Ref: 6/2018/2300/LB
Date: 13/11/2018

HISTORIC BUILDINGS AND CONSERVATION ADVICE

RE: Oshwal Centre, Coopers Lane Road, Northaw, Potters Bar, EN6 4DG

The application is for the omission of 5 no. rooflights from the south-facing roofslope of the rear extension approved under 6/2017/2594/LB.

SECTION BB' – WITHOUT ROOFLIGHTS (SCALE 1:50)

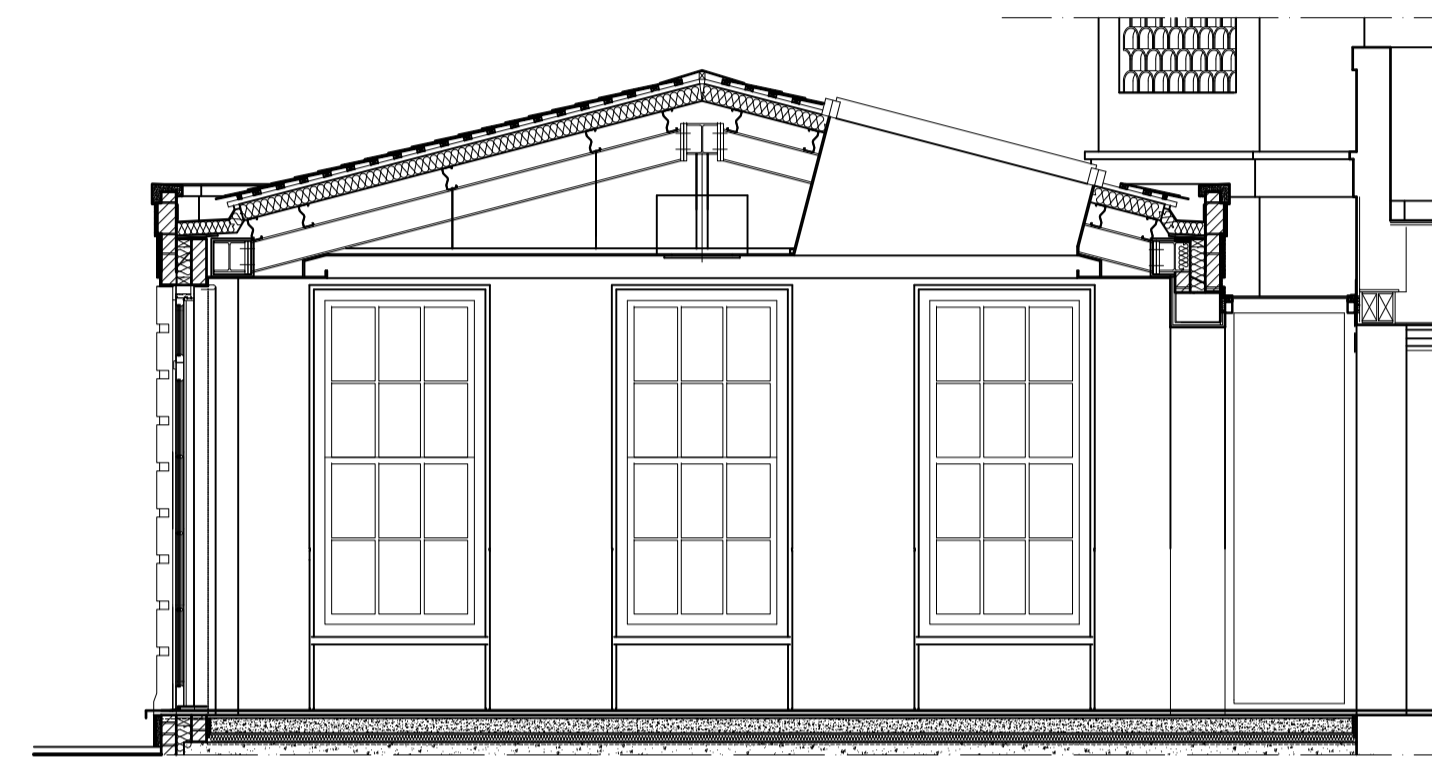
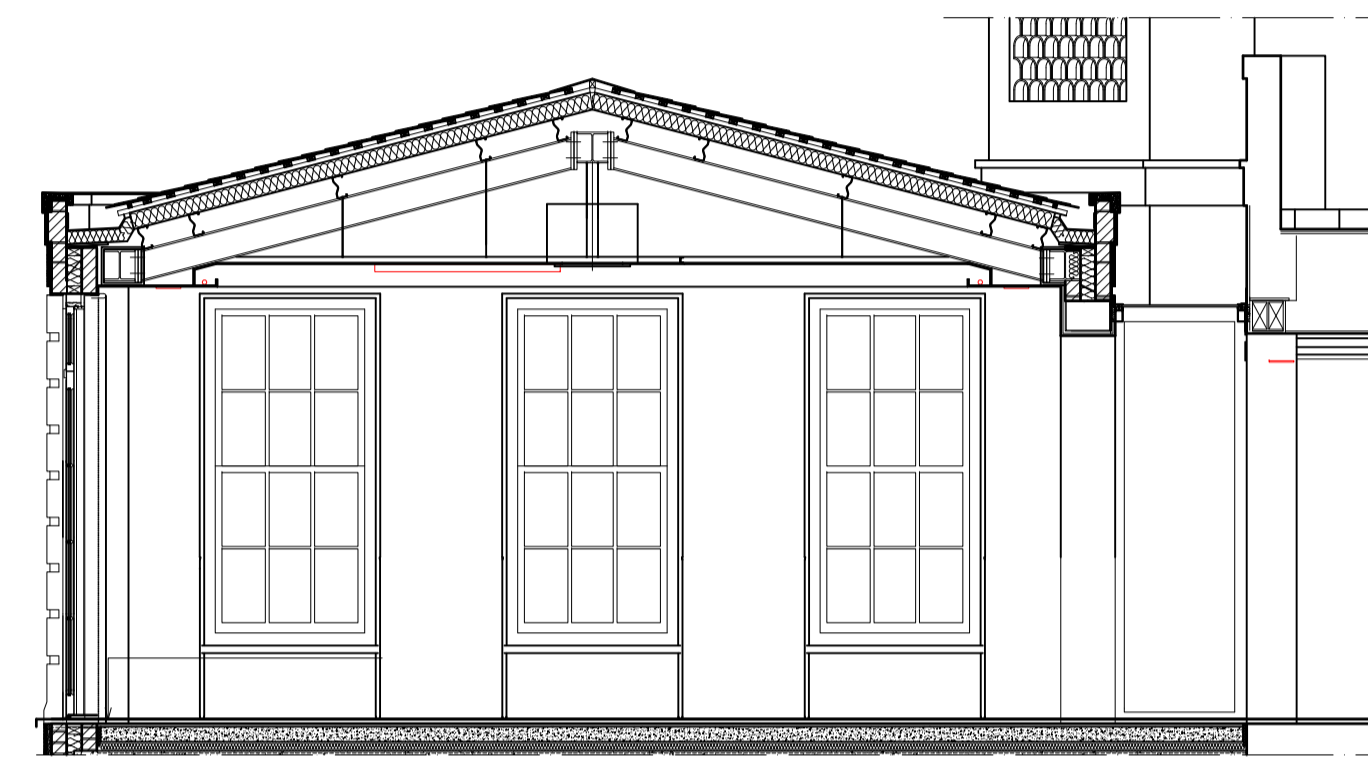
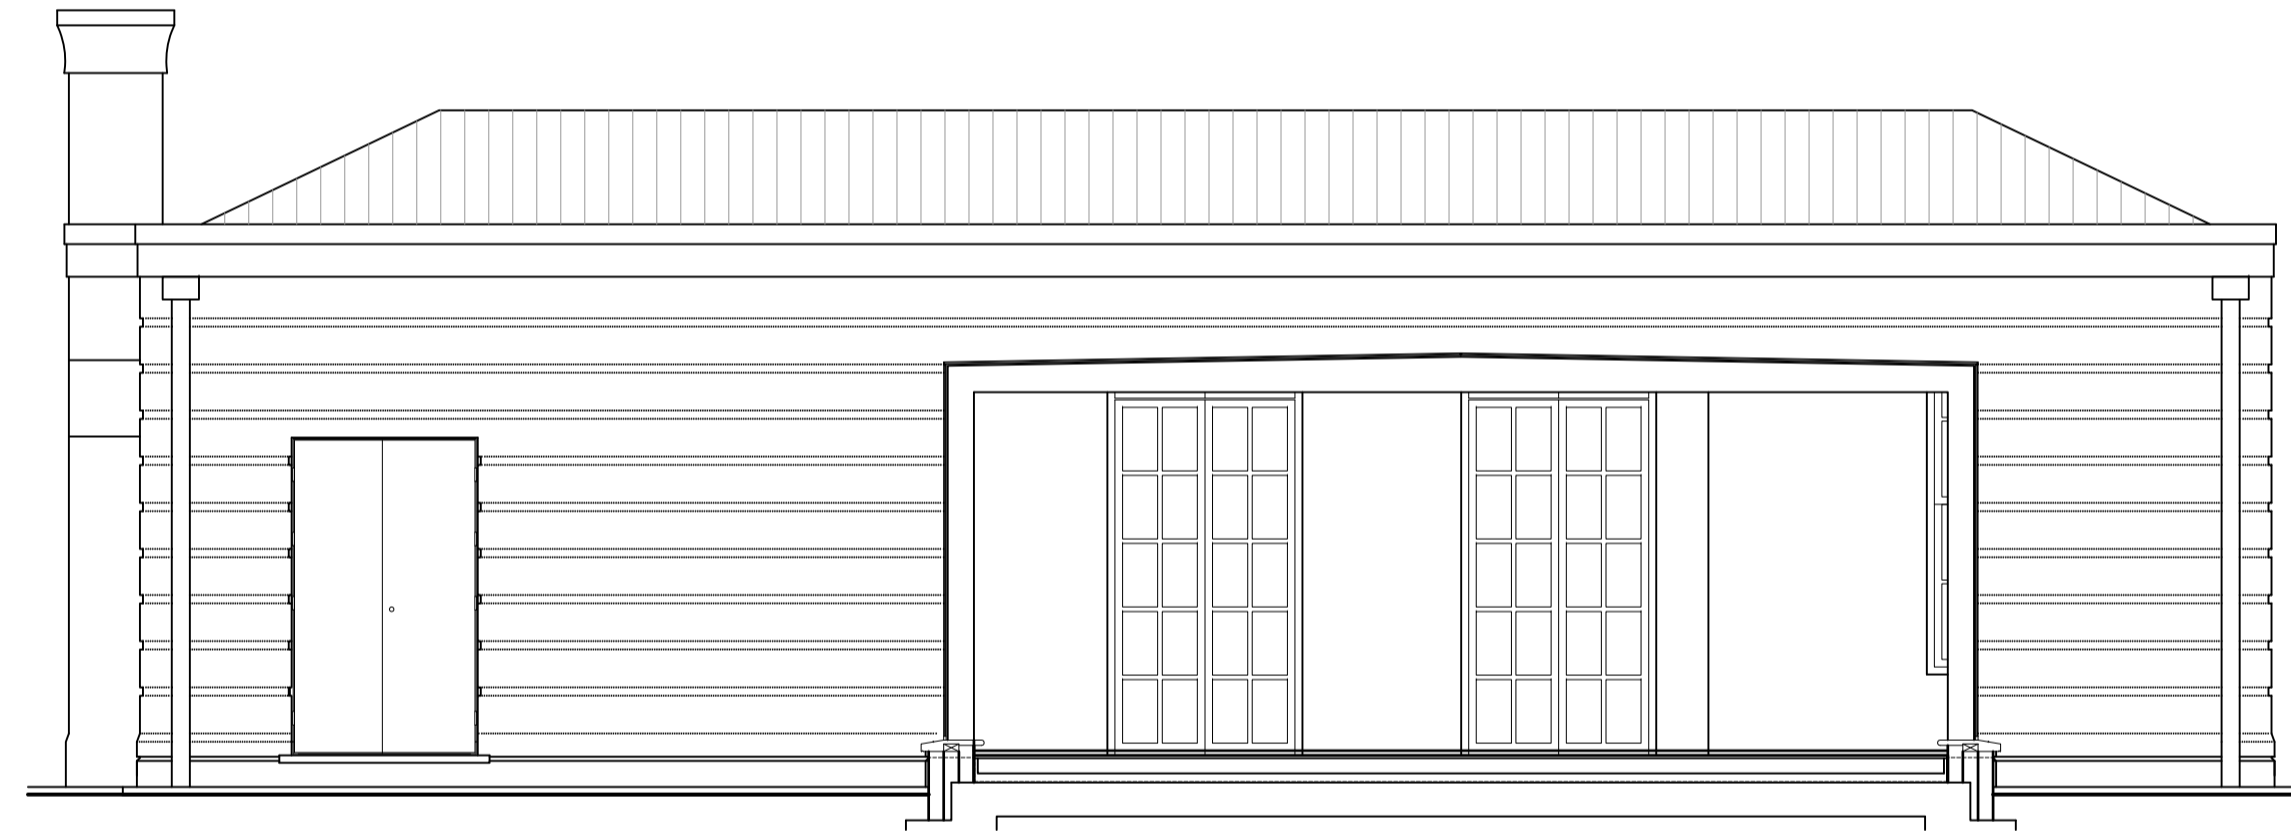
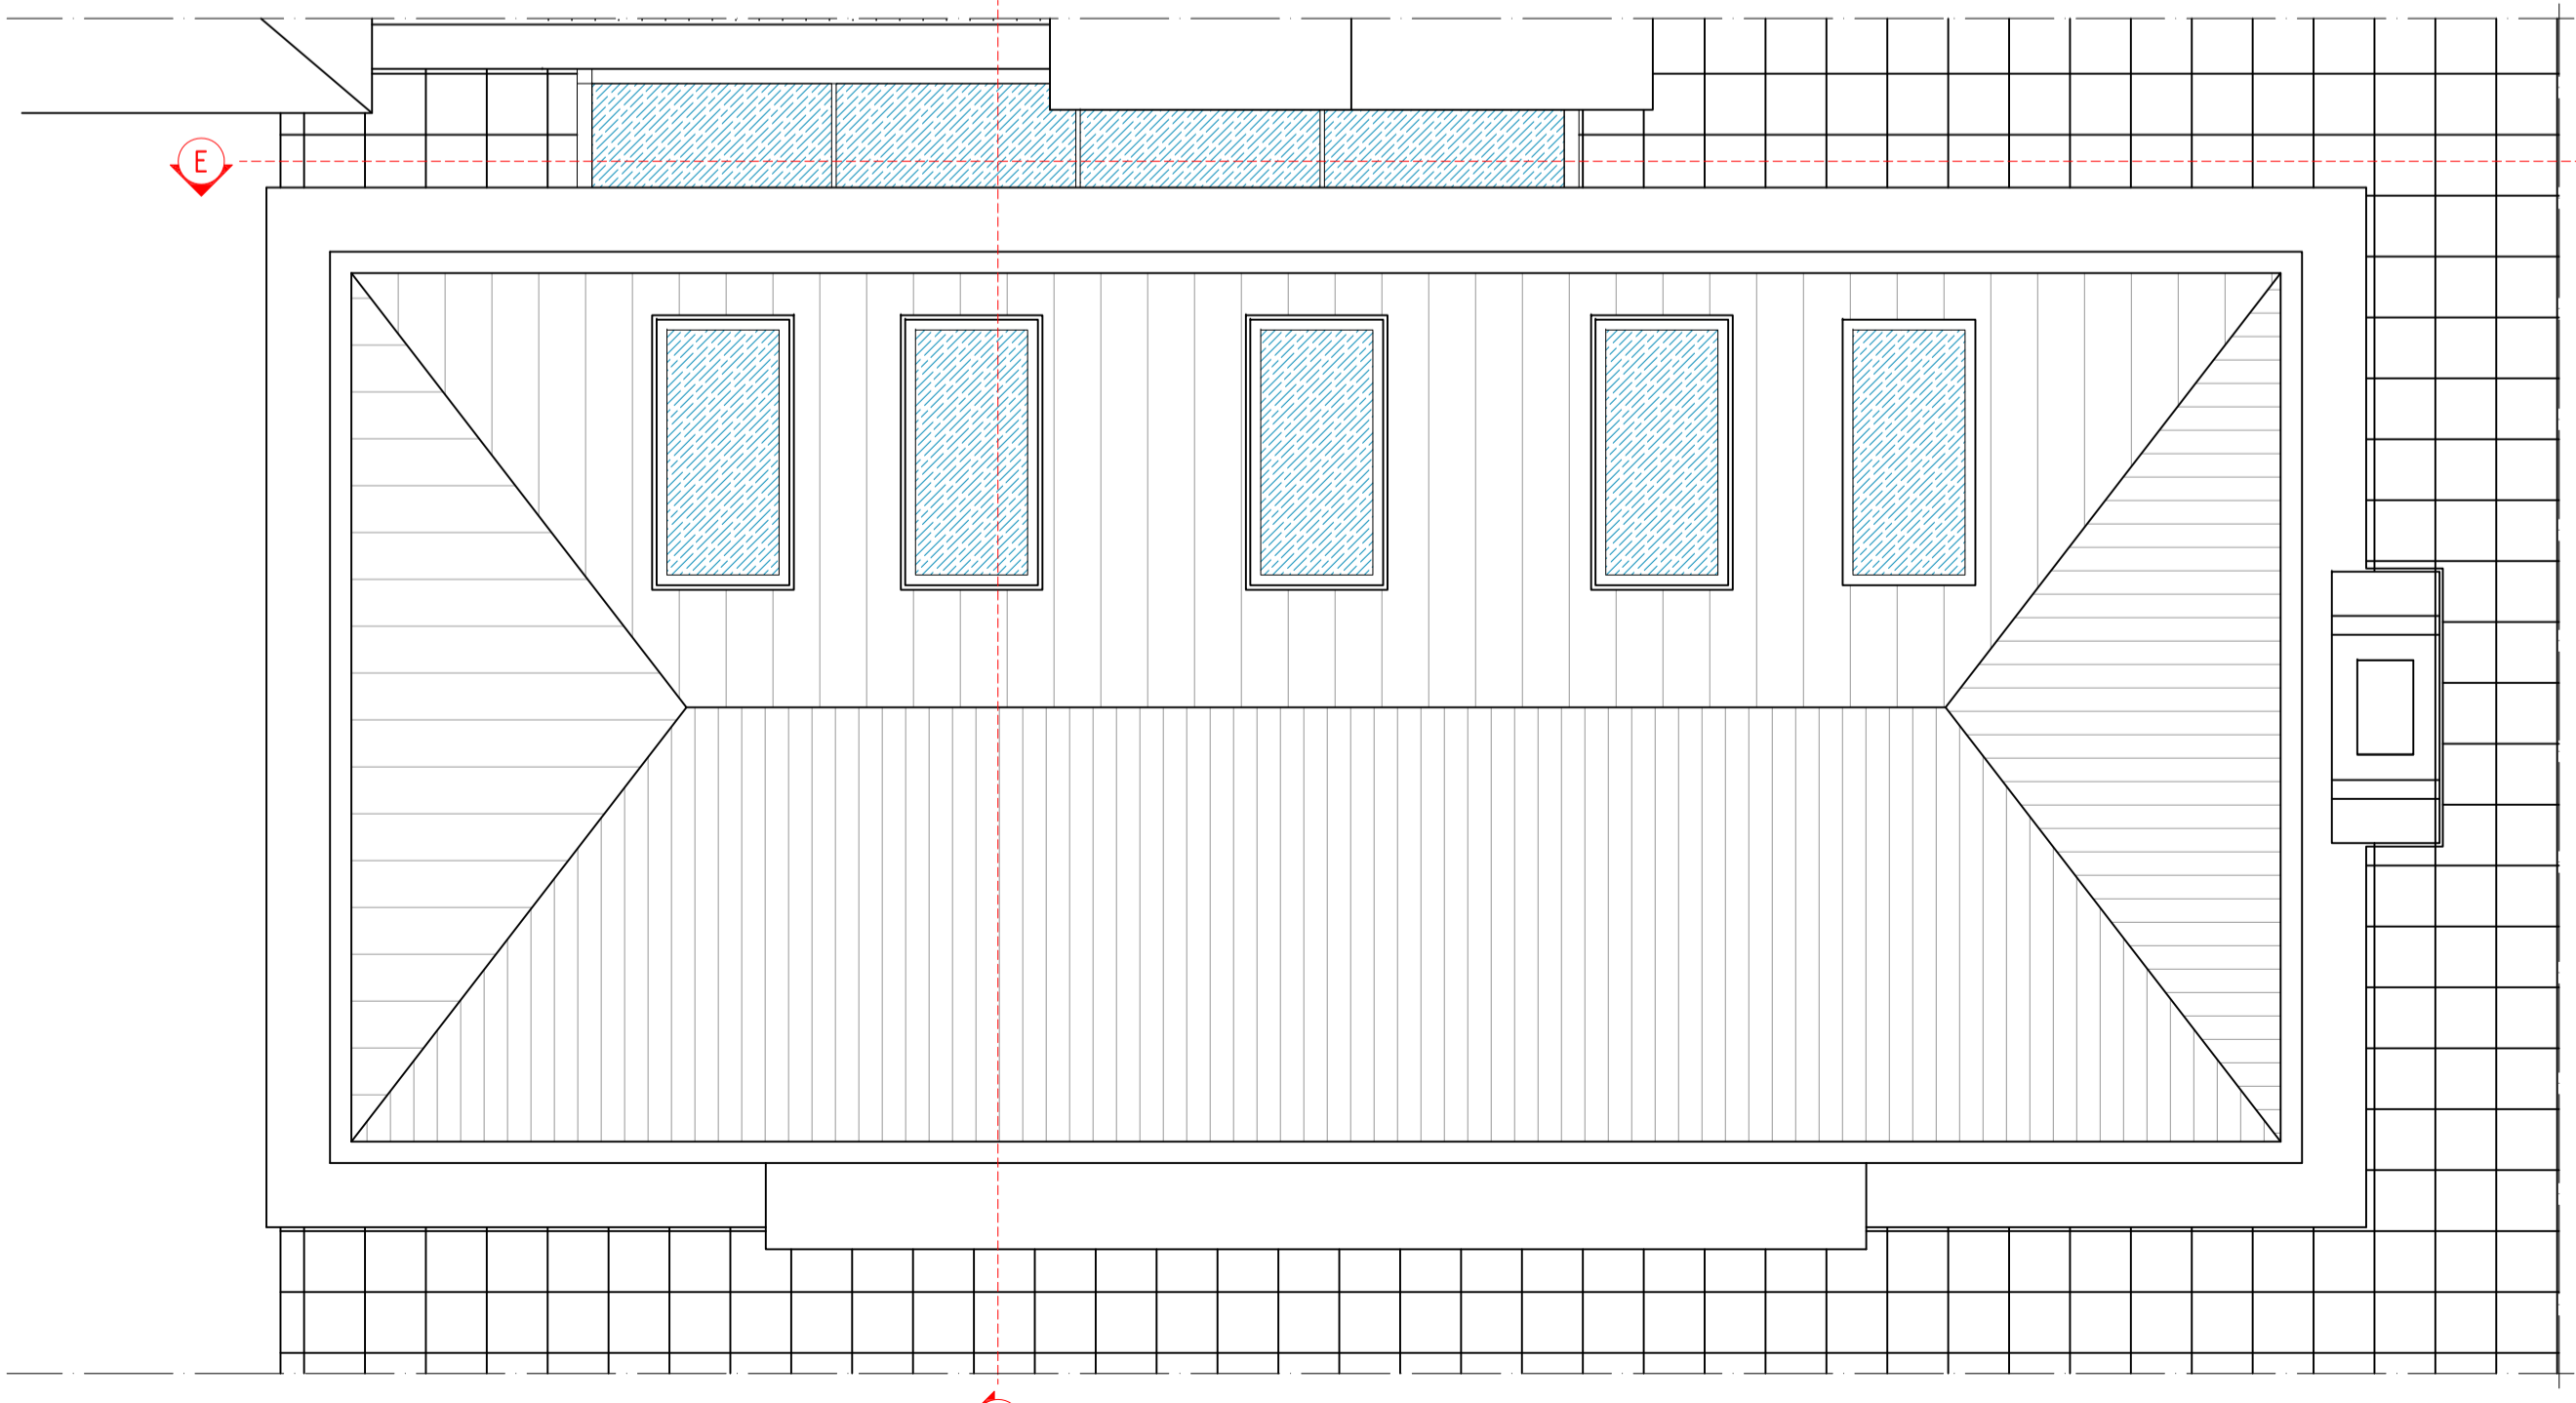
The omission of the rooflights on the south-facing roofslope (facing the rear of the house) of the new extension raises no objections. Their removal is considered to be an enhancement to the scheme as it simplifies the roof scape and the solid, uninterrupted roof is less of a visual distraction.
